Office of
Environment
& Heritage

WestConnex New M5 (SSI 6788) - Amended Submission

Attachment 1: The proposed WestConnex New M5 (SSI 6788) - Office of Environment and Heritage comments – 15 February 2016

Figure 5: Vegetation zones, PCTs, EECs and management zones within impact area – Map 1

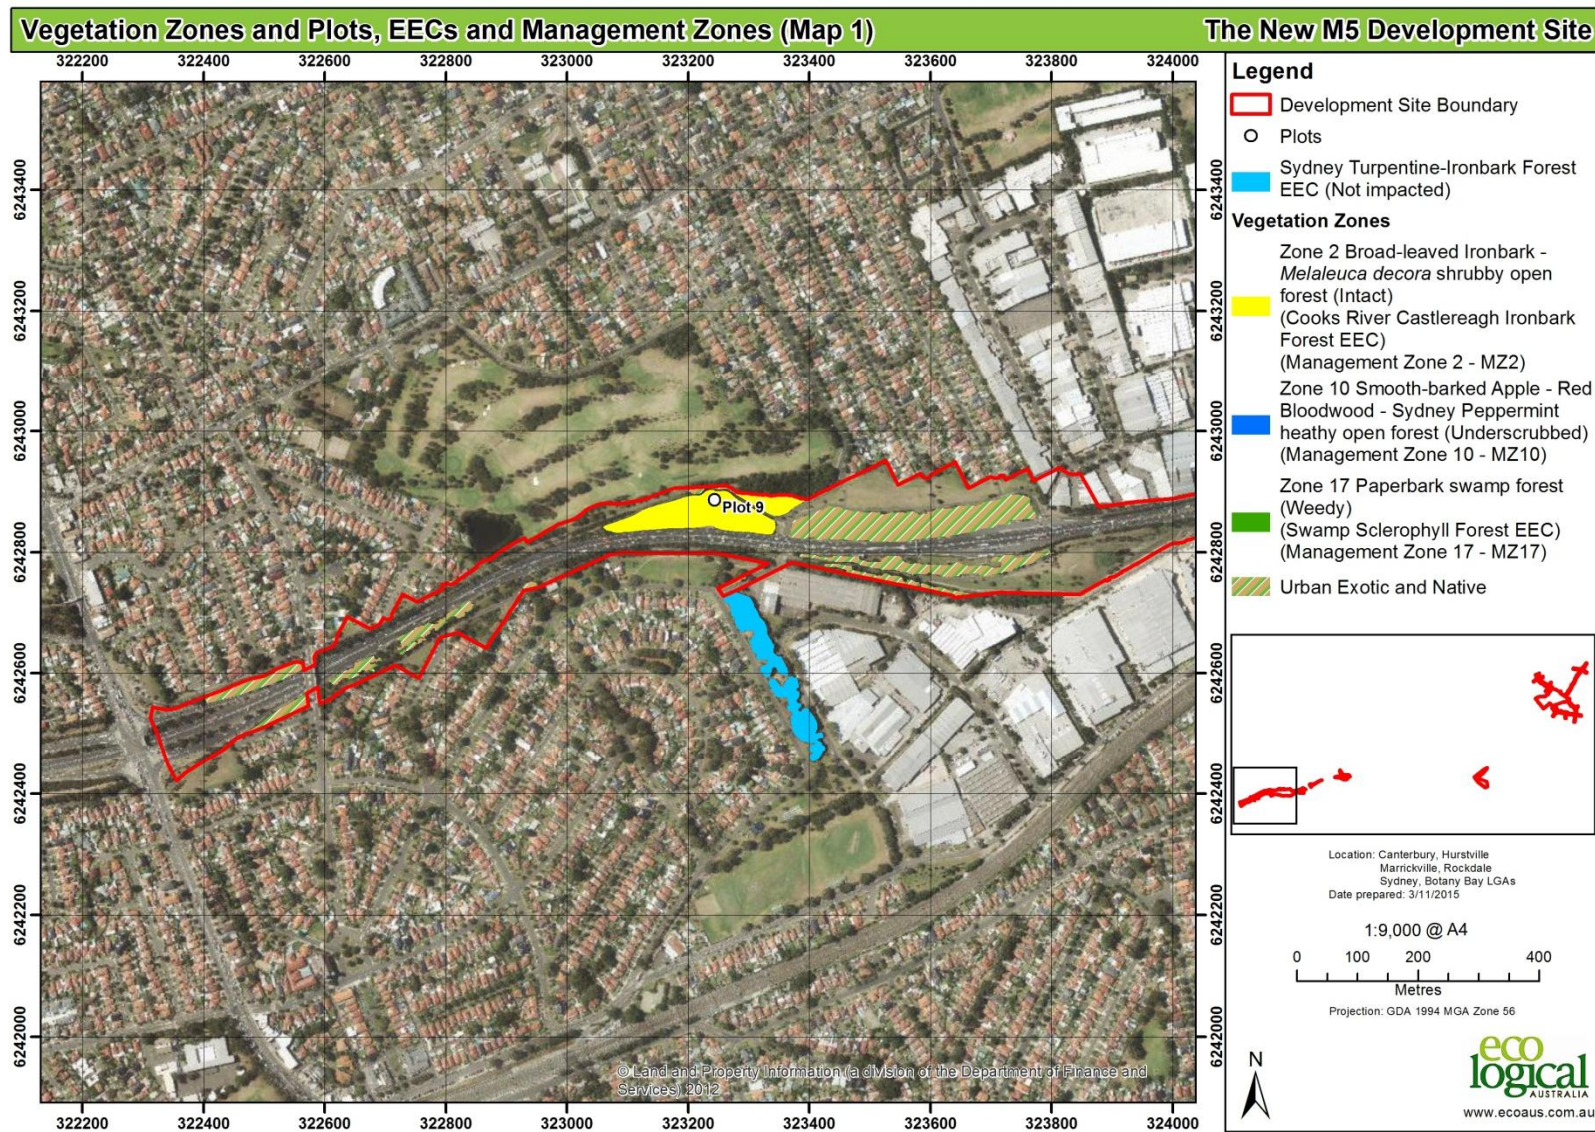
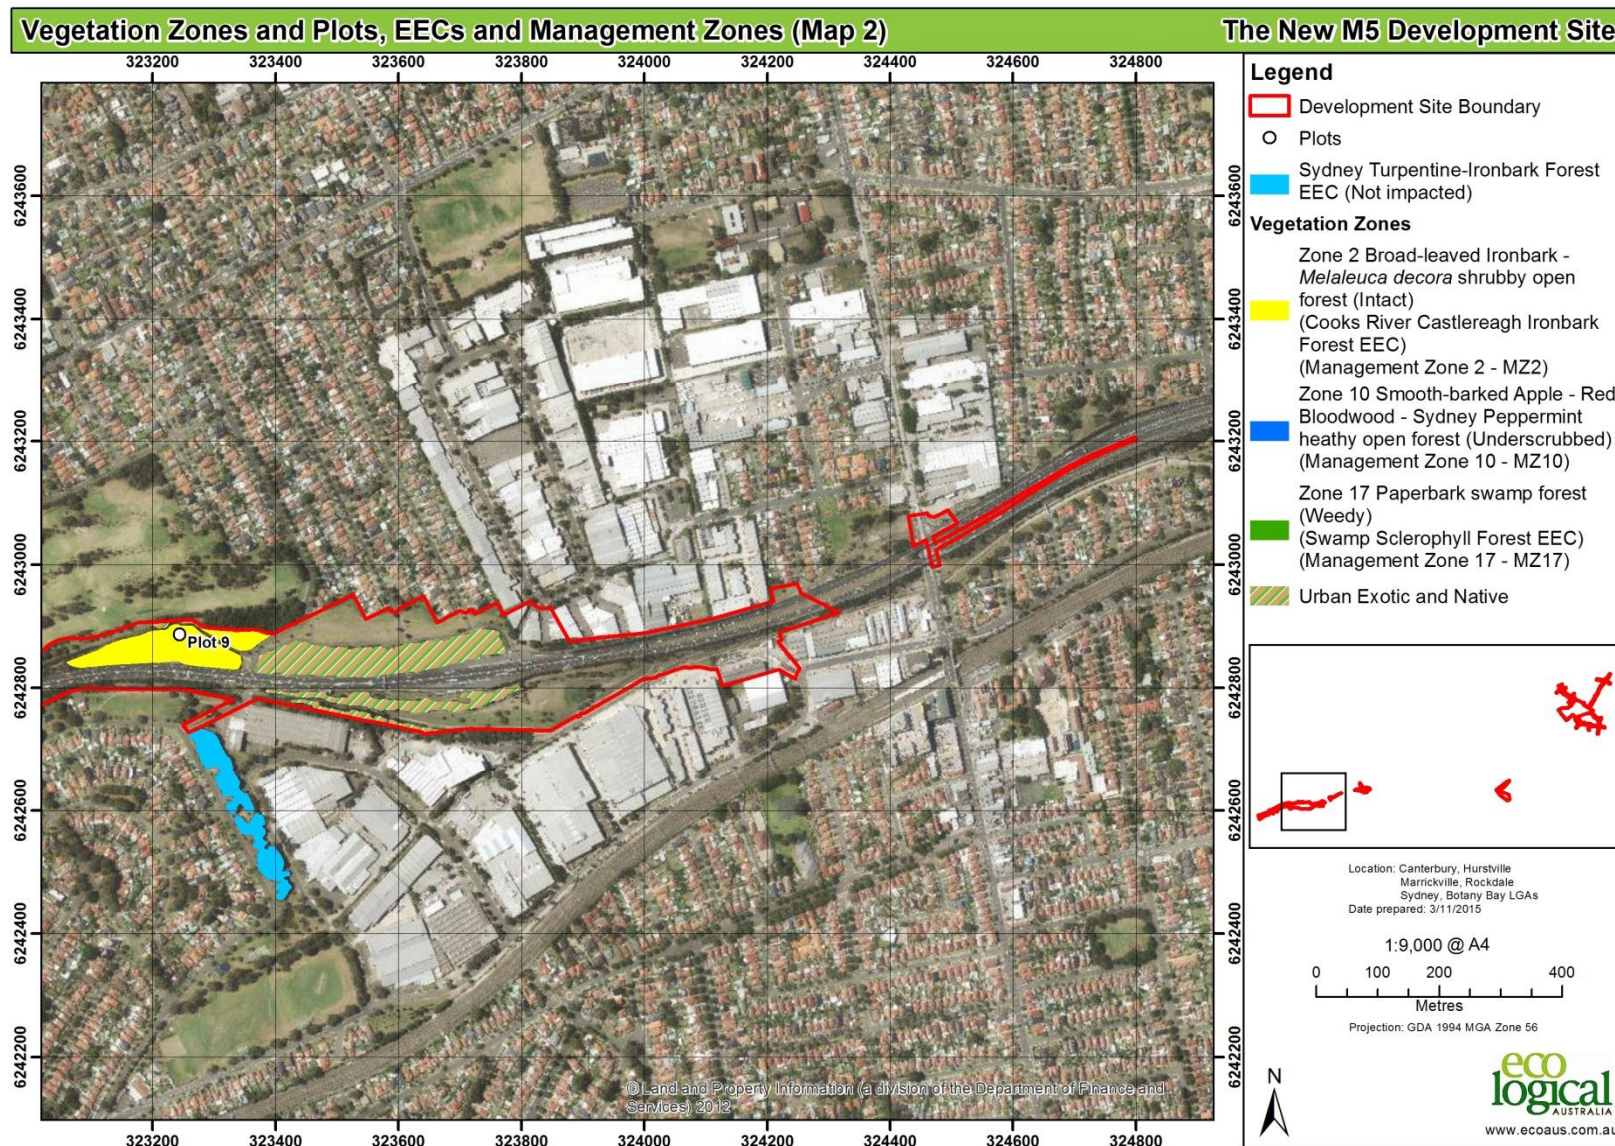
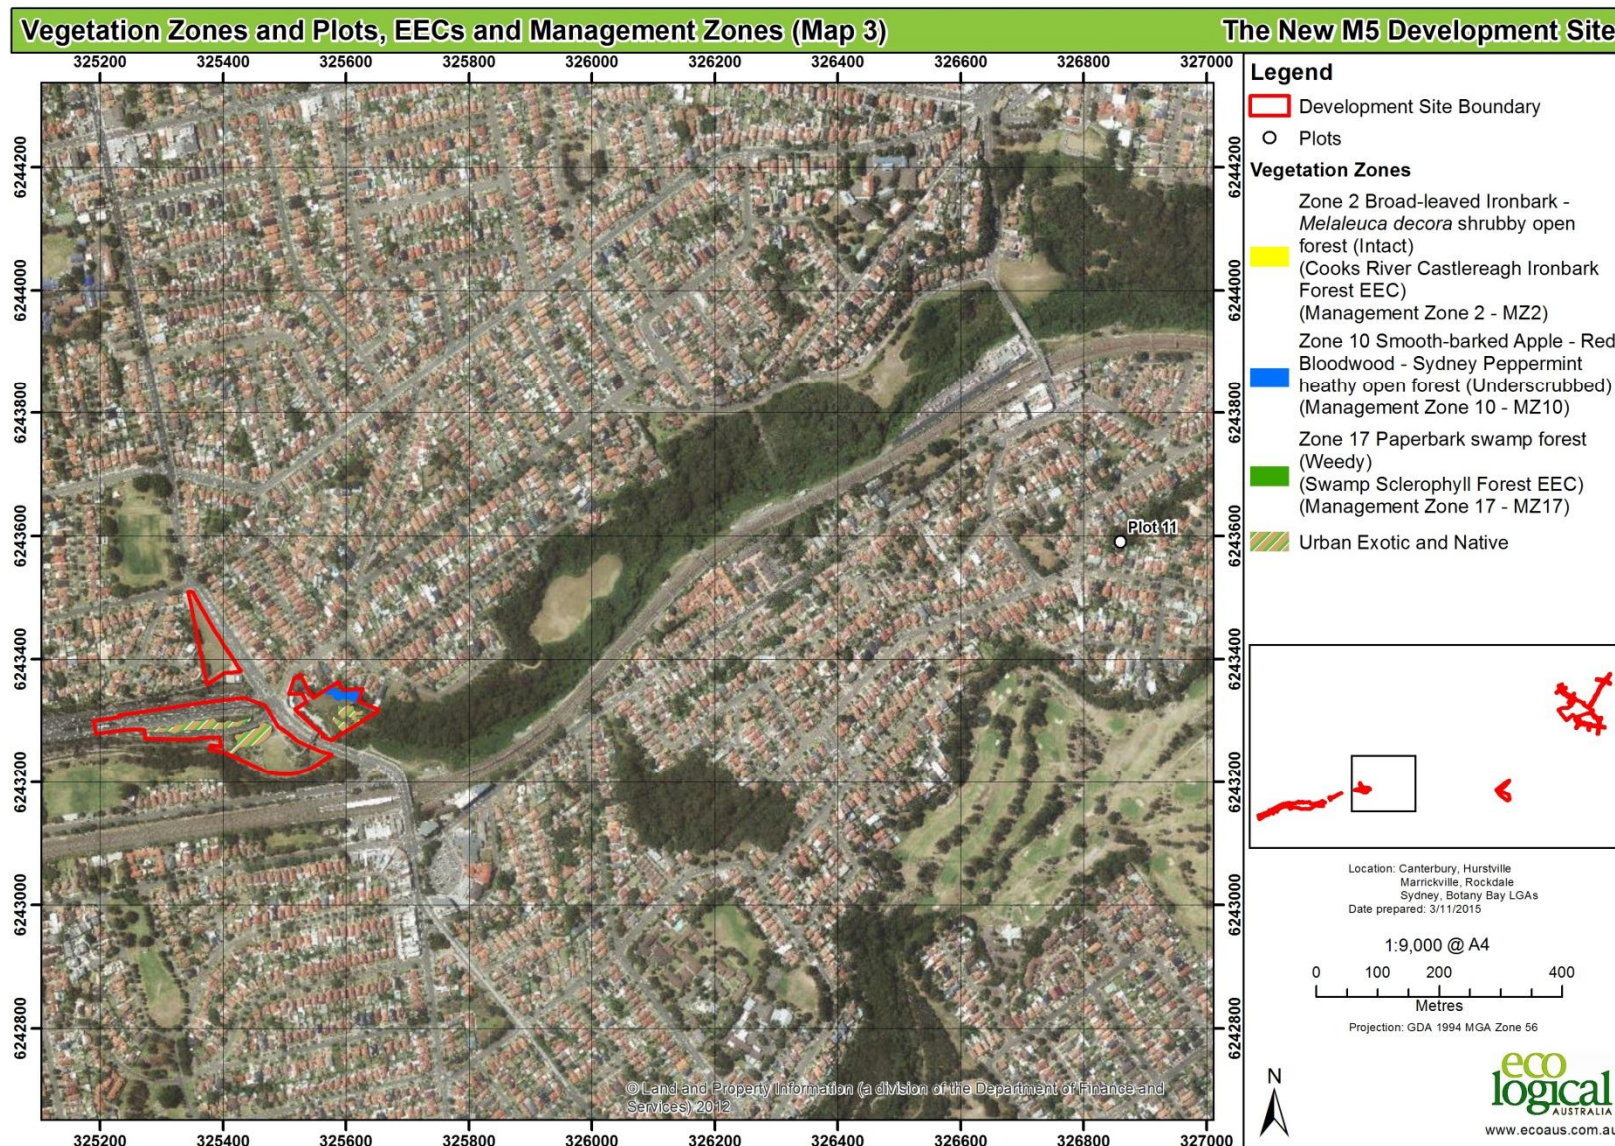
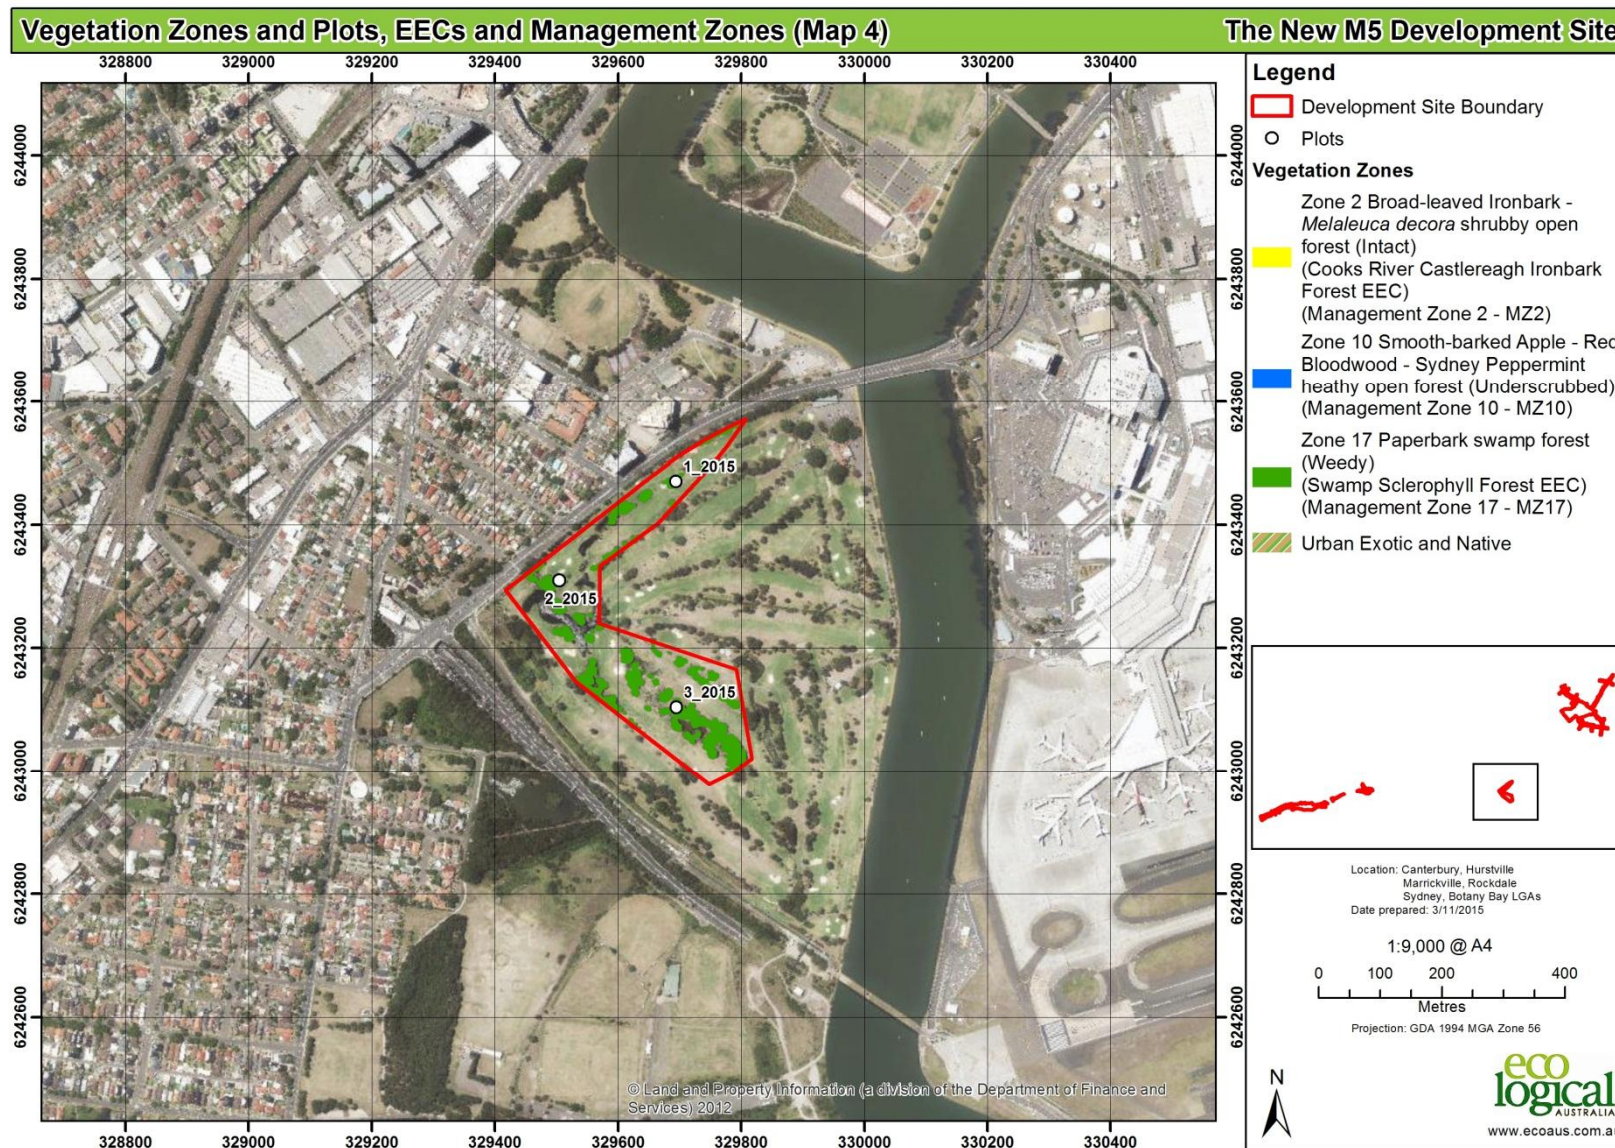
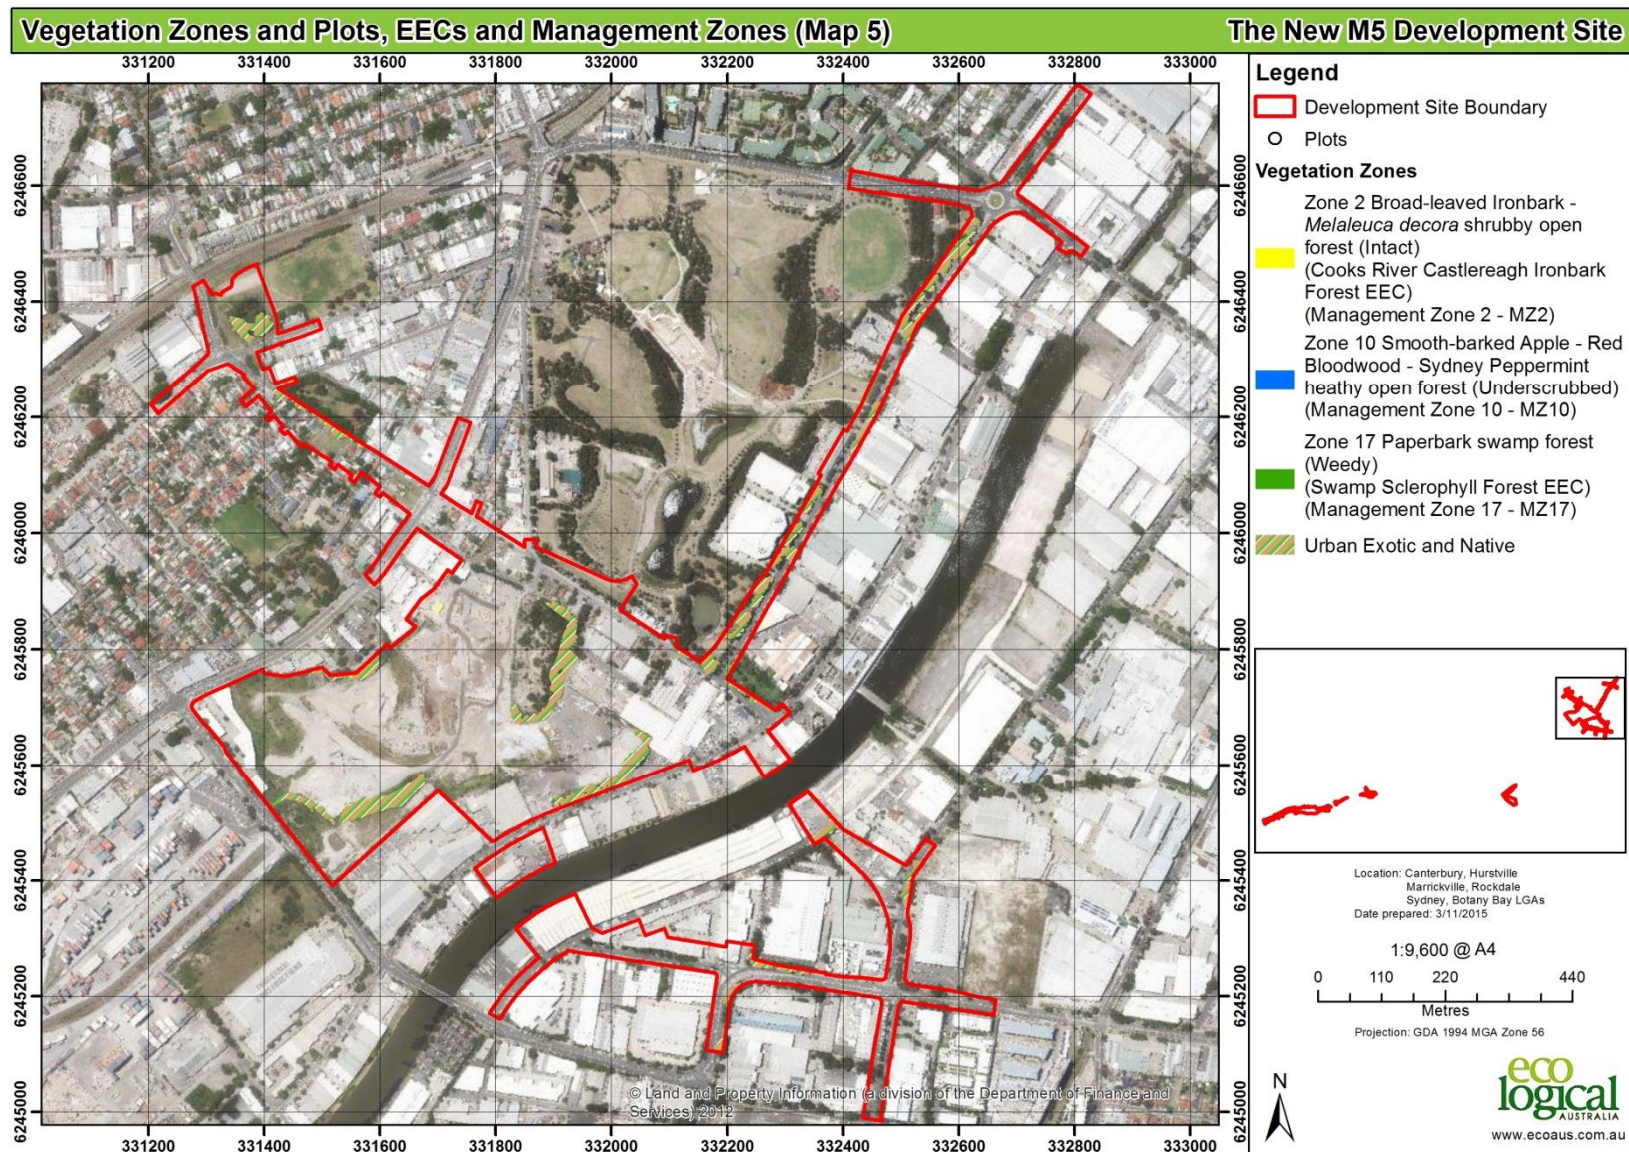
Cooks River Castlereagh Ironbark Forest	<p>The BAR includes analysis of direct and indirect impacts at Table 16.</p> <p>Direct loss of 1.4 ha. Minor fragmentation impacts by reduction in remnant size from 2.0 ha to 0.6 ha.</p> <p>As stated in Table 16, “the landscape context within which this remnant exists is currently already highly urbanised and fragmented”. Additionally, OEH considers that there will be minimal increases in edge effects because this remnant is nearly all edge already and has only been maintained in its current condition through active management by RMS since the construction of the existing M5 motorway.</p>
---	---

EPBC-listed ecological community	PCT	Area	Credits required
CRCIF	725	1.4	31
TOTAL		1.4	31
